**Subject: Villawood Soil Remediation Project
Project Approval 09_0147
Modification Request 1**

Further to our letter of 20 February 2013, Orica is pleased to provide further details in support of our application to modify the above Project Approval to clarify our proposal that untreated and treated water storage be in the form of in-ground, clay- and plastic-lined ponds.

Appendix E – Water Storage Ponds

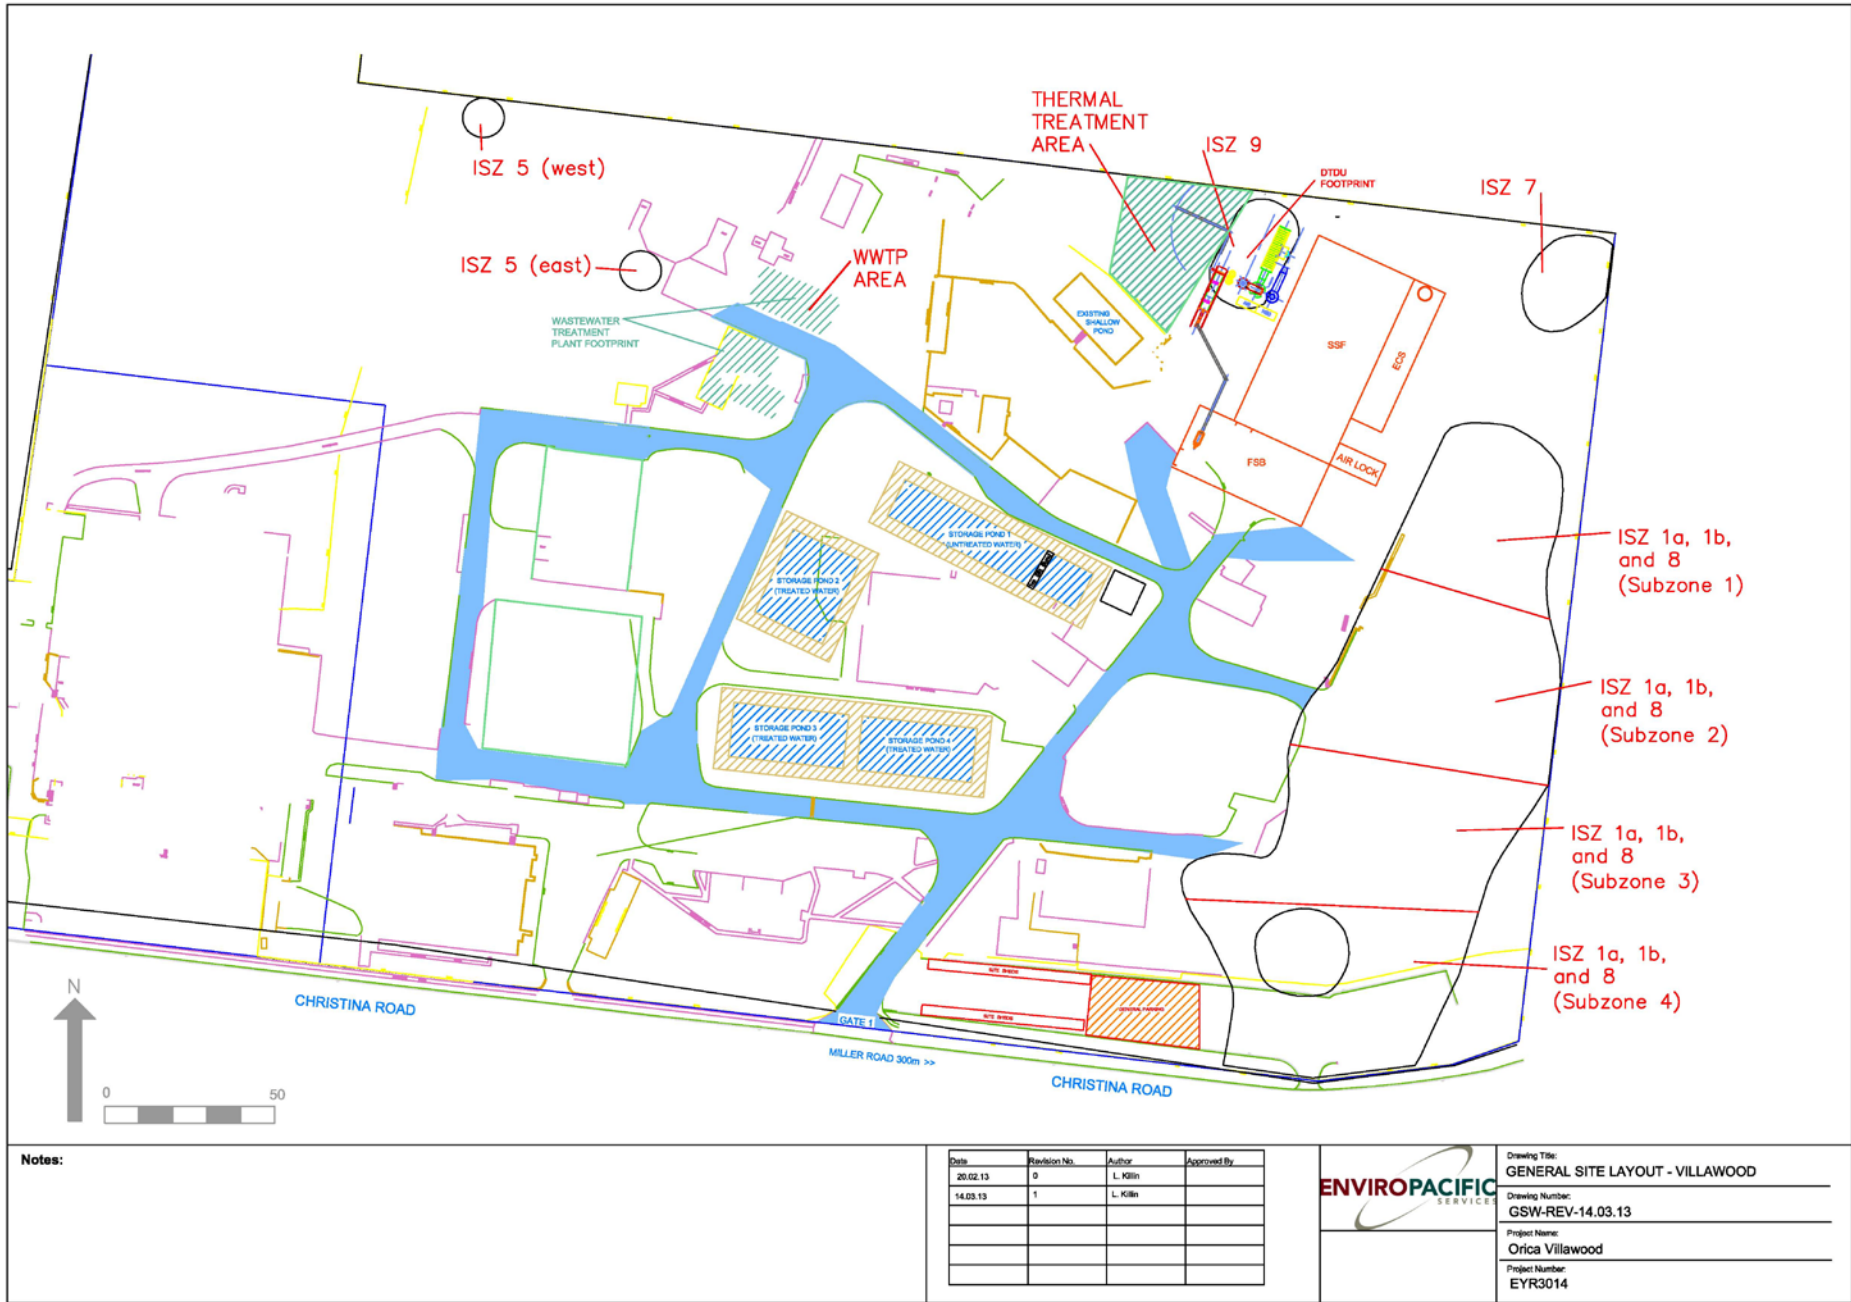
The large volumes of the storage tanks – up to 1,600 m³ – and other constraints and considerations mean the most practical way of providing this capacity is in in-ground tanks in the form of clay- and HDPE-lined ponds.

The storage ponds will be carefully constructed via a cut-to-fill exercise, along with a small amount of importation and placement of clay materials to line the ponds. An outline of construction methodology for the ponds is provided below:

- Remove existing out-of-service trade waste lines, locate potentially impacted stormwater infrastructure and complete any required modifications;
- Excavate base of pond and shape and compact walls;
- Inspect base of pond for any potential penetrating objects, such as steel or jagged concrete or rocks and remove as required;
- Import and place clay liner as required on areas with potential to penetrate pond liners;
- Place layer of geofabric on base of pond;
- Excavate anchor trenches around pond walls to 0.5 m depth x 0.5 m wide, or as required by geotechnical engineer;
- Place and weld layer of HDPE across pond, with sufficient overlap for anchor trenches; and
- Fill pond with 100 mm of clean water to stabilise.

Pond bases and walls will be covered in impervious HDPE plastic for the duration of the project, thereby preventing potential erosion and eliminating the potential spread of this material to downstream areas. At completion of the works, the ponds will be emptied and plastic liners disposed of to a licensed waste disposal facility. The pond walls will be reused to backfill the ponds back to grade, and the area will be regressed.

- The ponds will be operated close to empty but in all circumstances at least 300 mm below the top and there will also be a high and a high-high alarm in the untreated (contaminated) water pond;
- The ponds will be subject to daily visual inspection;
- There is approximately 150 m³ of storage on the site in the form of existing, serviceable tanks and bunds; and
- As a last resort, offsite transport and disposal of liquid waste is available, but is not desirable due to the high additional cost, additional carbon footprint, and increased risk of an offsite environmental impact during transport.

For reasons of practicality, sustainability and cost, Orica proposes to use in-ground, clay- and HDPE-lined ponds for water storage.
